The Town and Country Planning (Environmental Impact Assessment) Regulations 2017 ('The EIA Regulations')

Application No.: 24/00539/F

Applicant's Name: Oxford United Football Club Limited

Proposal: Erection of a stadium (Use Class F2) with flexible commercial and community facilities and uses including for conferences, exhibitions, education, and other events, club shop, public restaurant, bar, health and wellbeing facility/clinic, and gym (Use Class E/Sui Generis), hotel (Use Class C1), external concourse/fan-zone, car and cycle parking, access and highway works, utilities, public realm, landscaping and all associated and ancillary works and structures

APPENDIX A – MASTERPLAN

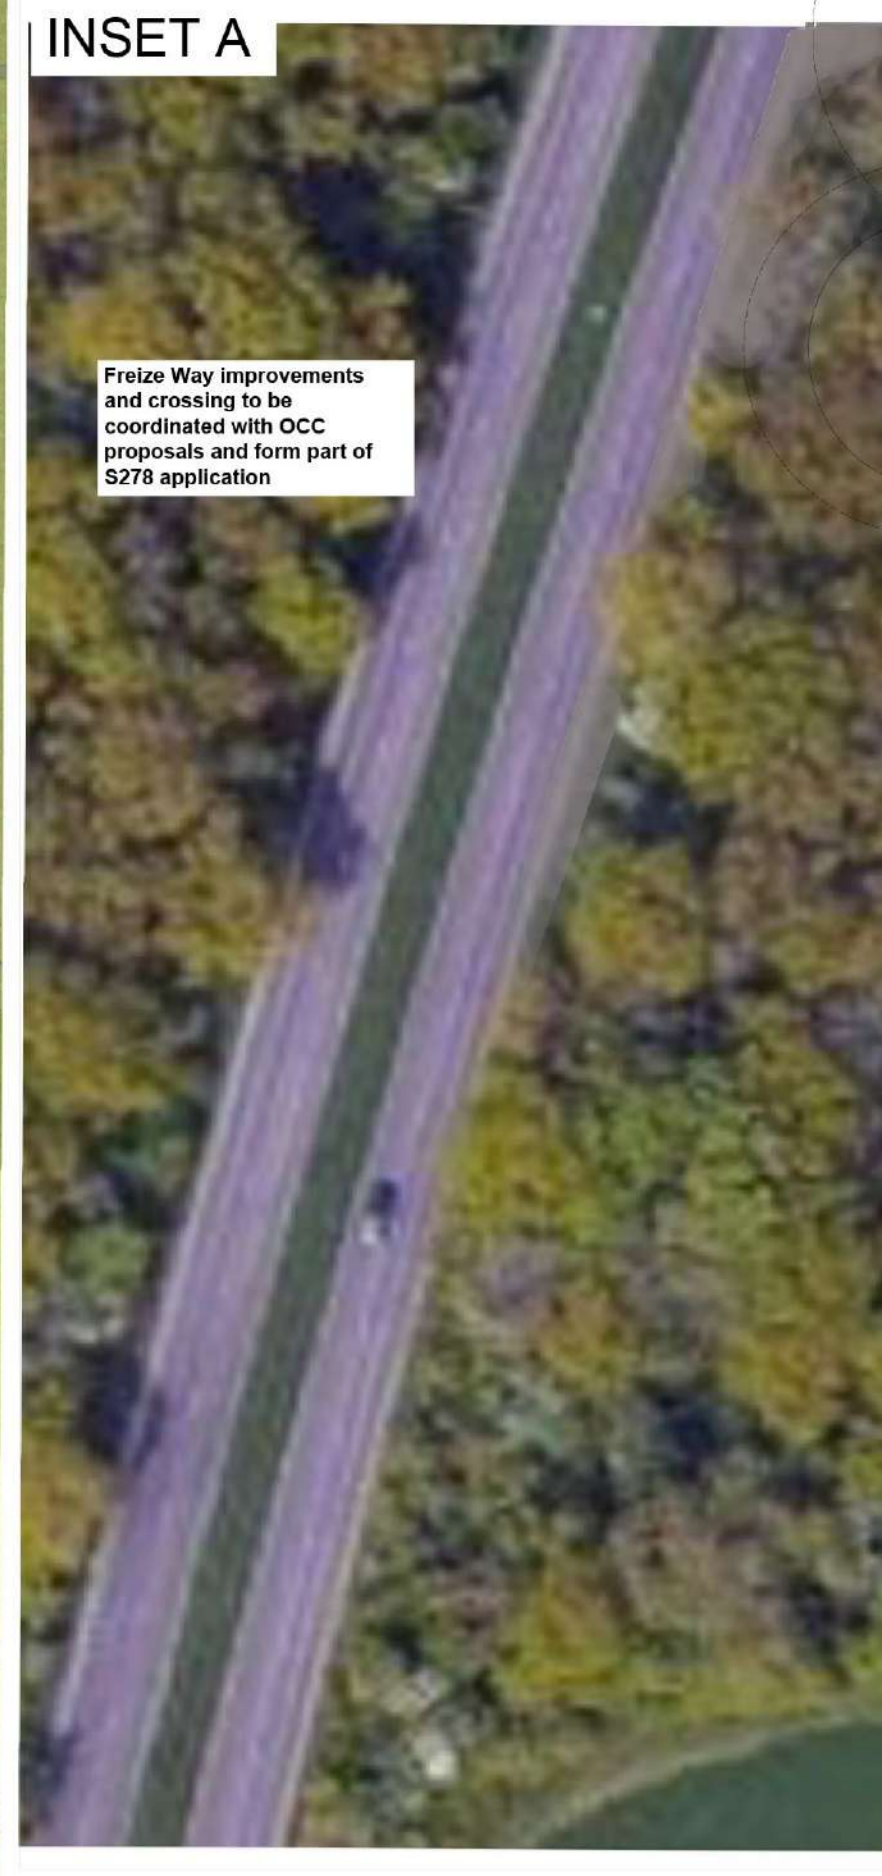
- The applicant must demonstrate how the proposed 'Cycle Superhighway' along Oxford Road will continue across their site frontage. The cycle superhighway must be continuous, which the current plans do not appear to show. The width of the cycle lane must be 2.5m with a 2m footway and floating bus stops. Again, due to the frequency of the bus services there must be a minimum of 2 bays with shelters and RTI displays.

- Further drawings of the access works are required showing detailed geometry and dimensions. The signalised crossing will need to be staggered unless the island is at least 5m wide. There should be no pedestrian fences and there should be room for bicycles with trailers to use the crossing easily. The crossing cannot be located within the slip road into the site so this needs to be redesigned and adequate drawings provided. At 30mph and with the level of traffic expected to use the access the slip road into the site is likely not required.
